**BusConnects Core Bus Corridors
- Belfield / Blackrock to City
Centre Core Bus Corridor**

Stage 1 Road Safety Audit

Document Ref: P20-138-PSW3-RP-001

<b>Programme Title</b> <b>BUSCONNECTS DUBLIN</b> <b>CORE BUS CORRIDORS INFRASTRUCTURE WORKS</b>			
<b>Drawing Title</b> BELFIELD / BLACKROCK TO CITY CENTRE CORE BUS CORRIDOR SCHEME GENERAL ARRANGEMENT			
Drawing File Name	Sheet Number	Status	Rev
BCIDC-ARP-GEO_GA-1415_XX_00-DR-CR-0007	07 of 24	A	M01

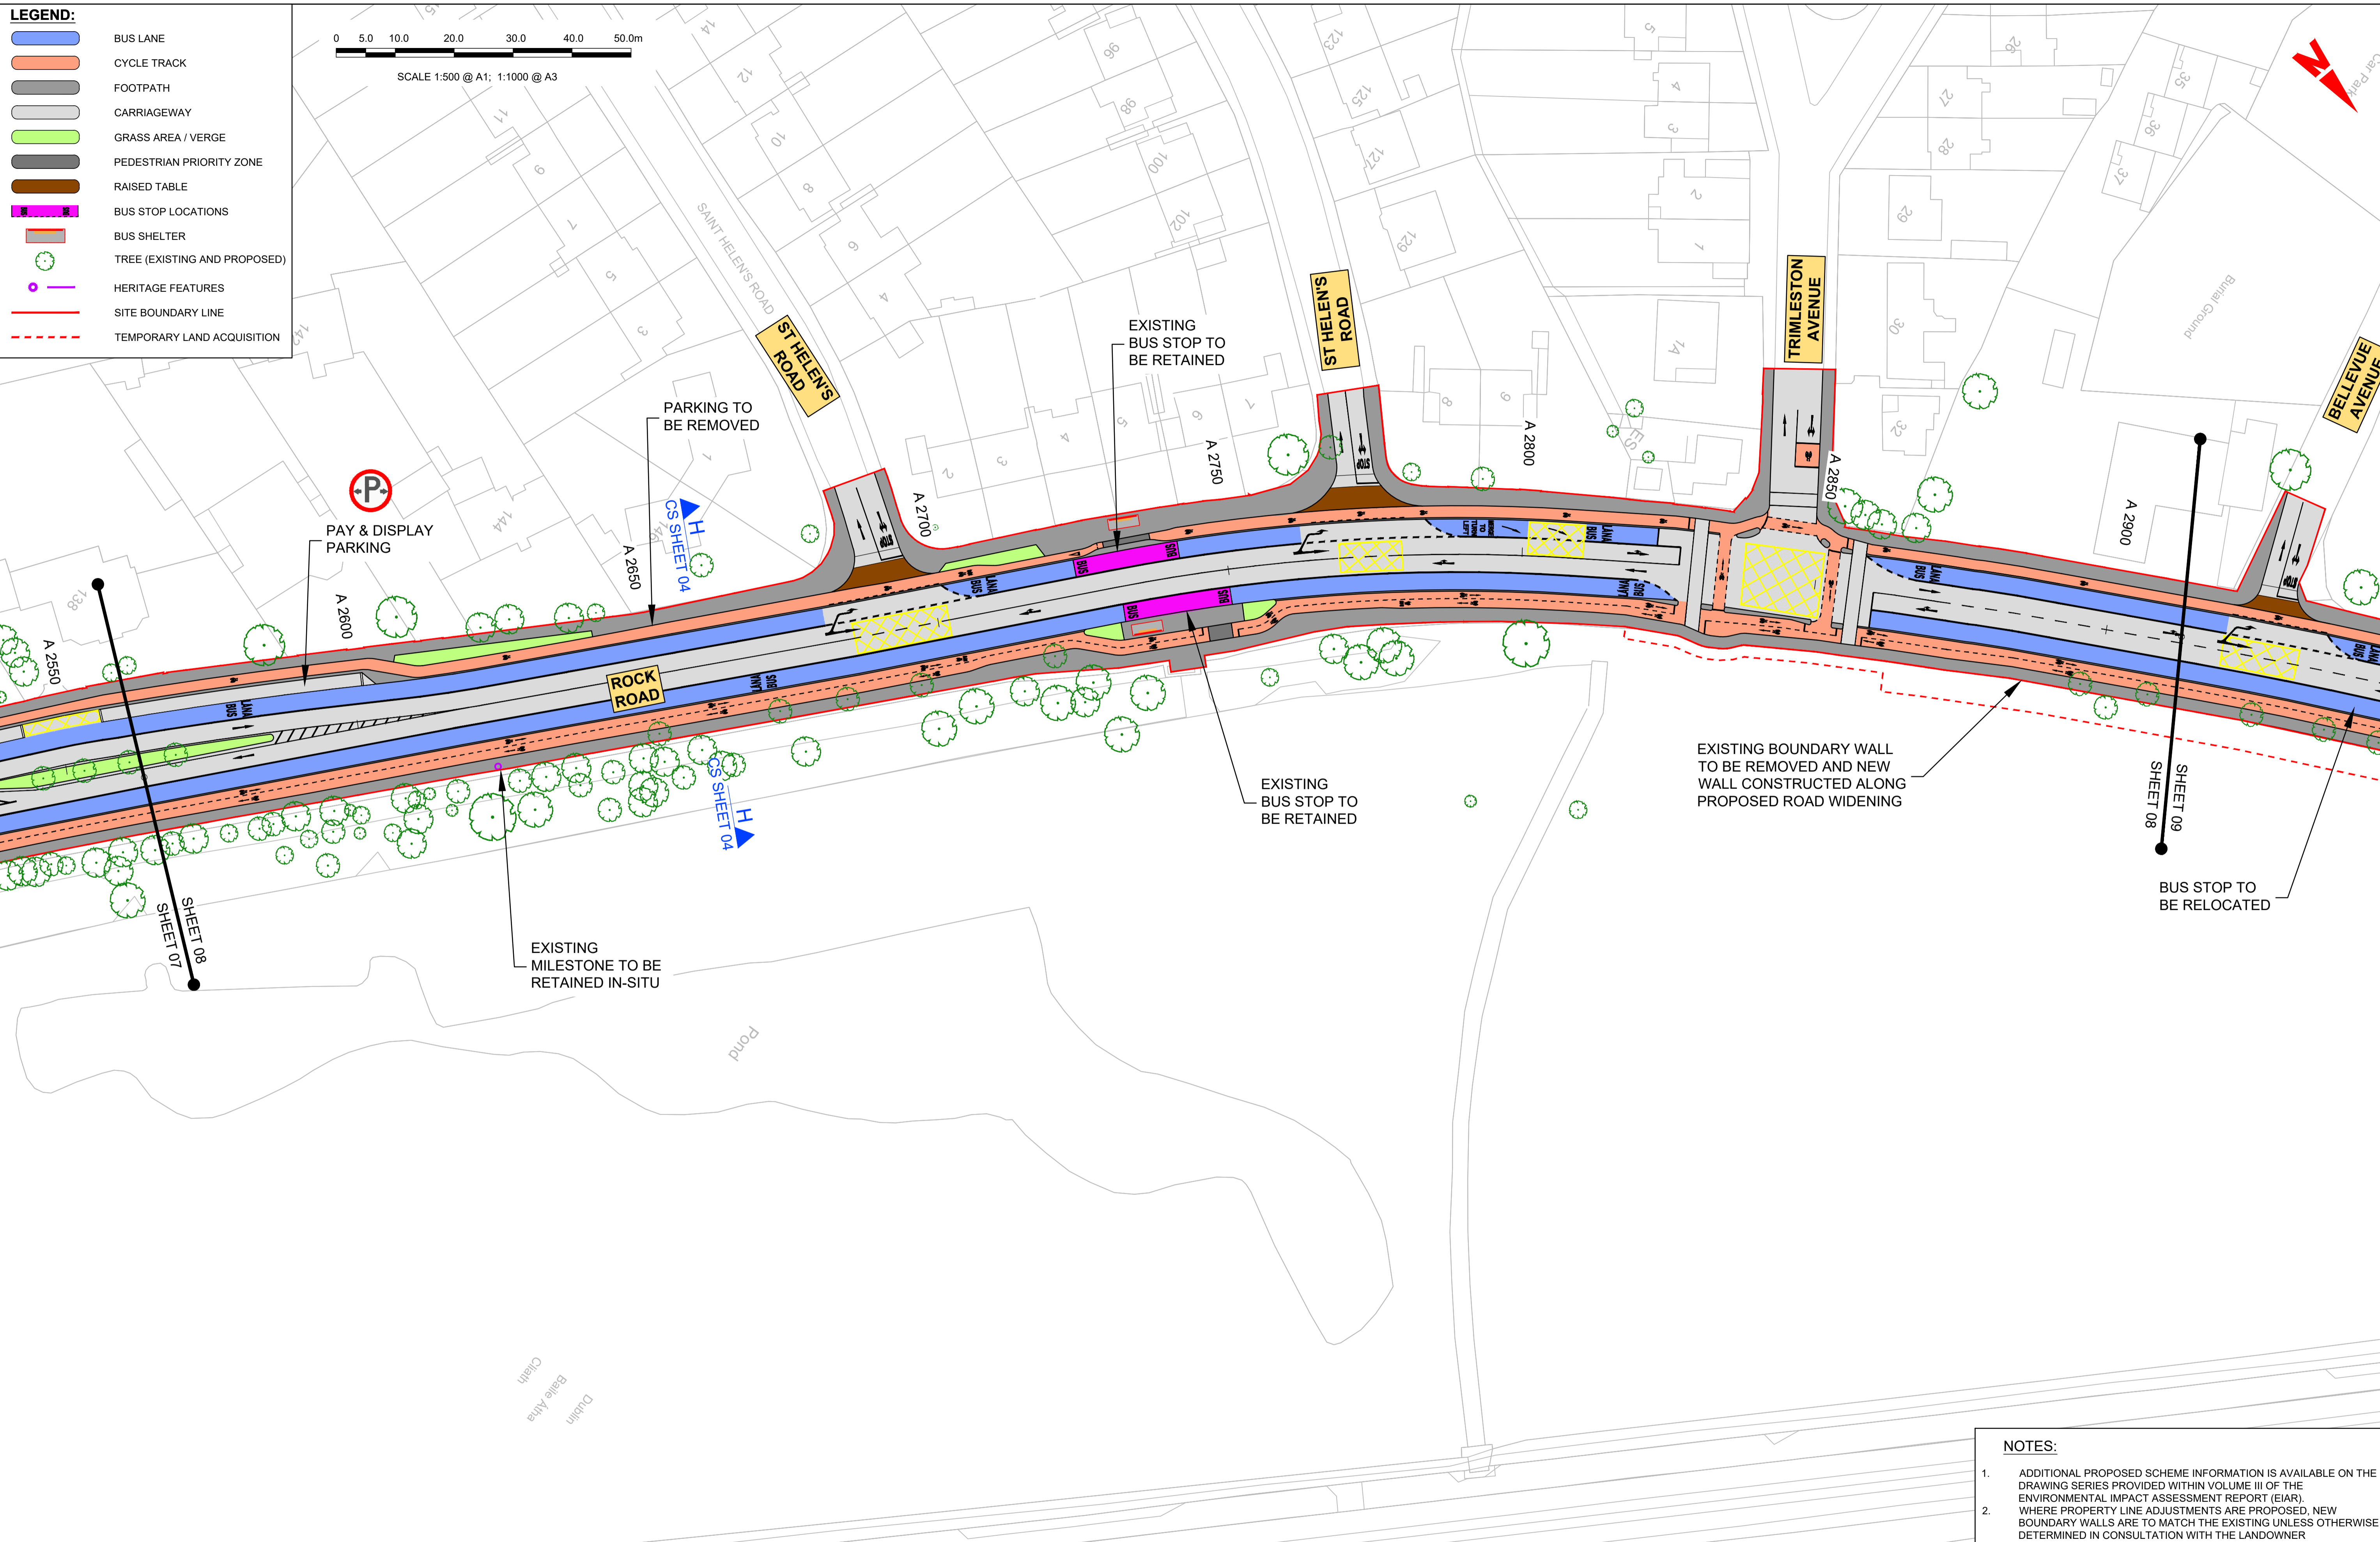
Location: BCIDC-ARP-GEO_GA-1415_XX_01-DR-CR-0005 (Rev L01) and BCIDC-ARP-GEO_GA-1415_XX_01-DR-CR-0007 (Rev L01)

Summary: Visibility (to cyclists/pedestrians) for drivers turning left into a side road may be impeded by vehicles parked in the parallel parking bays, leading to vehicle/pedestrian and vehicle/cyclist collisions.

Vehicles occupying parking areas or set-down areas may block visibility towards cyclists and pedestrians on the footway, resulting in possible vehicle/pedestrian and vehicle/cyclist collisions when traffic turns left into the respective side road.

Example: BCIDC-ARP-GEO_GA-1415_XX_01-DR-CR-0007 (Rev L01)

Summary: It is unclear if there will be sufficient space within the signalised junction to accommodate the swept path of all vehicles.

Information regarding the swept path of vehicles undertaking turning movements at proposed signalised junctions within the Scheme have not been provided to the Audit Team. The Audit Team are concerned that there will not be sufficient space at all junctions to accommodate the swept path of all vehicles, particularly HGVs and buses, within the proposed junction layouts. This is a particular concern where protected cycle lane infrastructure reduces the turning radii further.

Ensure sufficient inter-visibility between drivers and pedestrians/cyclists is provided at these locations.

A comprehensive swept path analysis should be undertaken to demonstrate that all new, and revised, signalised junctions can sufficiently accommodate the swept path of all vehicles. Where constraints are identified, the layout should be revised to ensure all vehicle movements can be accommodated.

Drawing File Name	BCIDC-ARP-GEO_GA-1415_XX_00-DR-CR-0023																																																									
Sheet Number	23 of 24																																																									
Status	A																																																									
Rev	M01

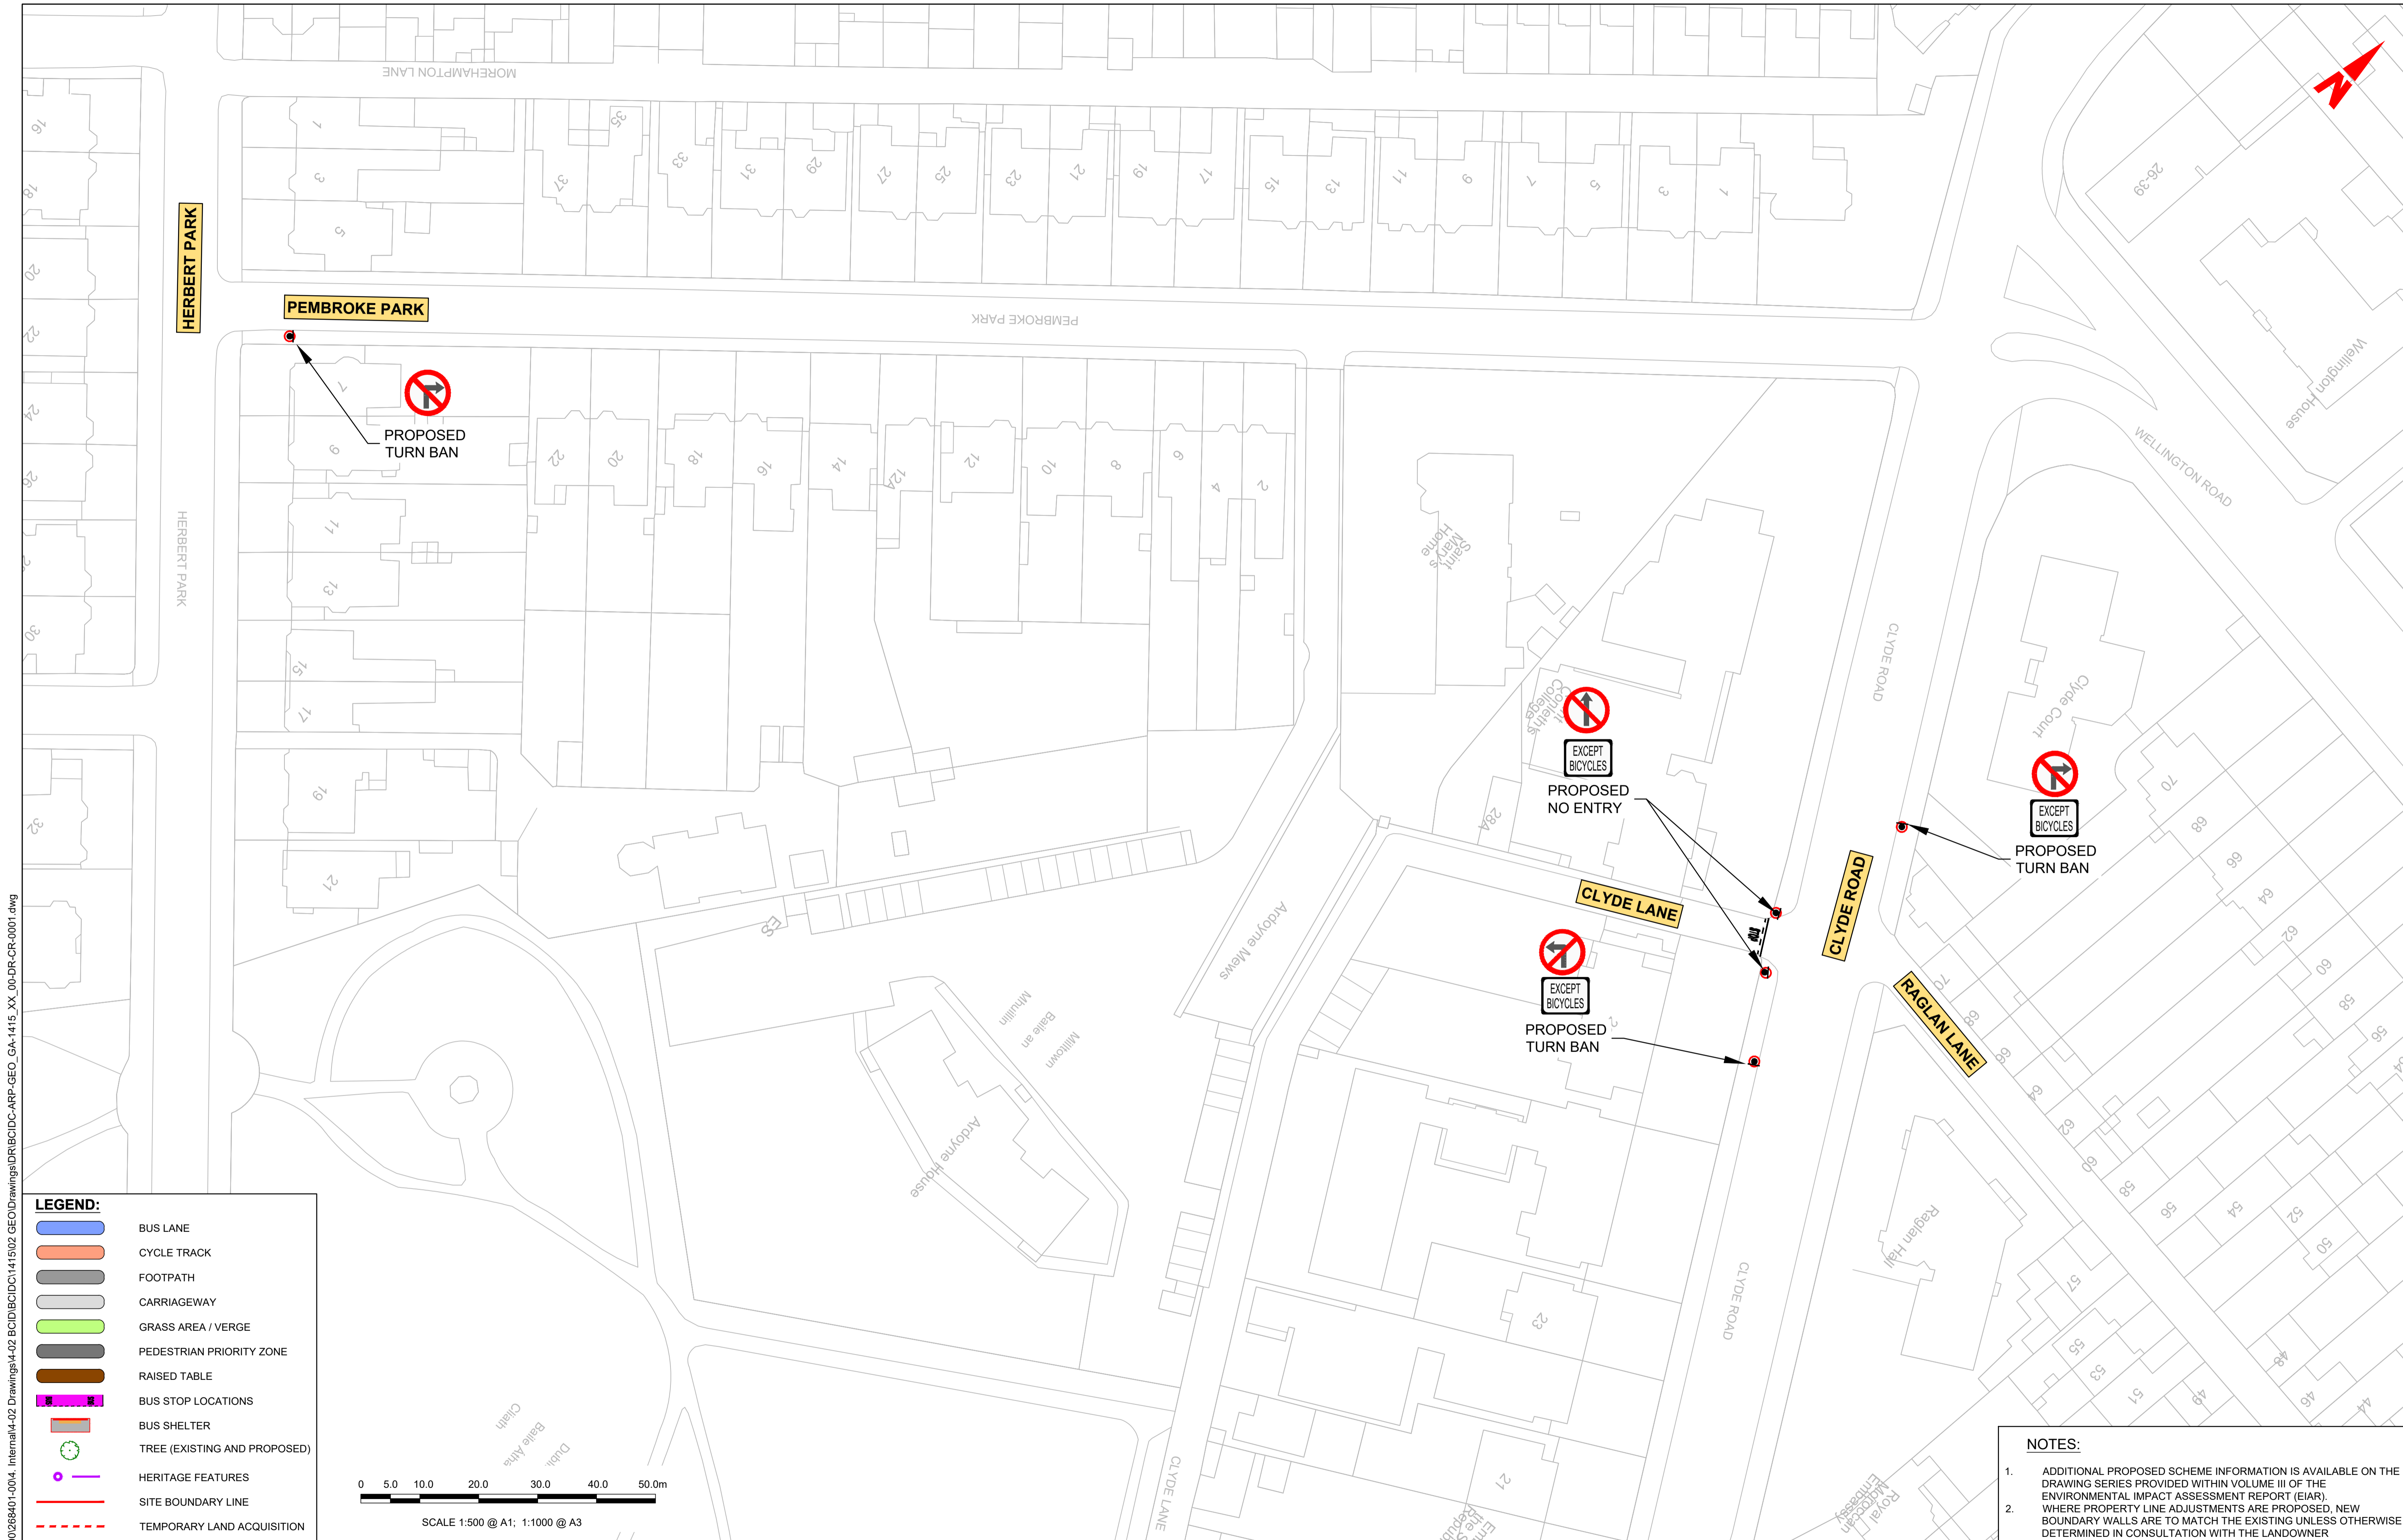
Example: BCIDC-ARP-GEO_GA-1415_XX_01-DR-CR-0023 (Rev L01)

Summary: Unclear if the crossings within signalised junctions will be Toucan crossings to allow cyclists to cross to other cycle facilities on the opposite side of the junction.
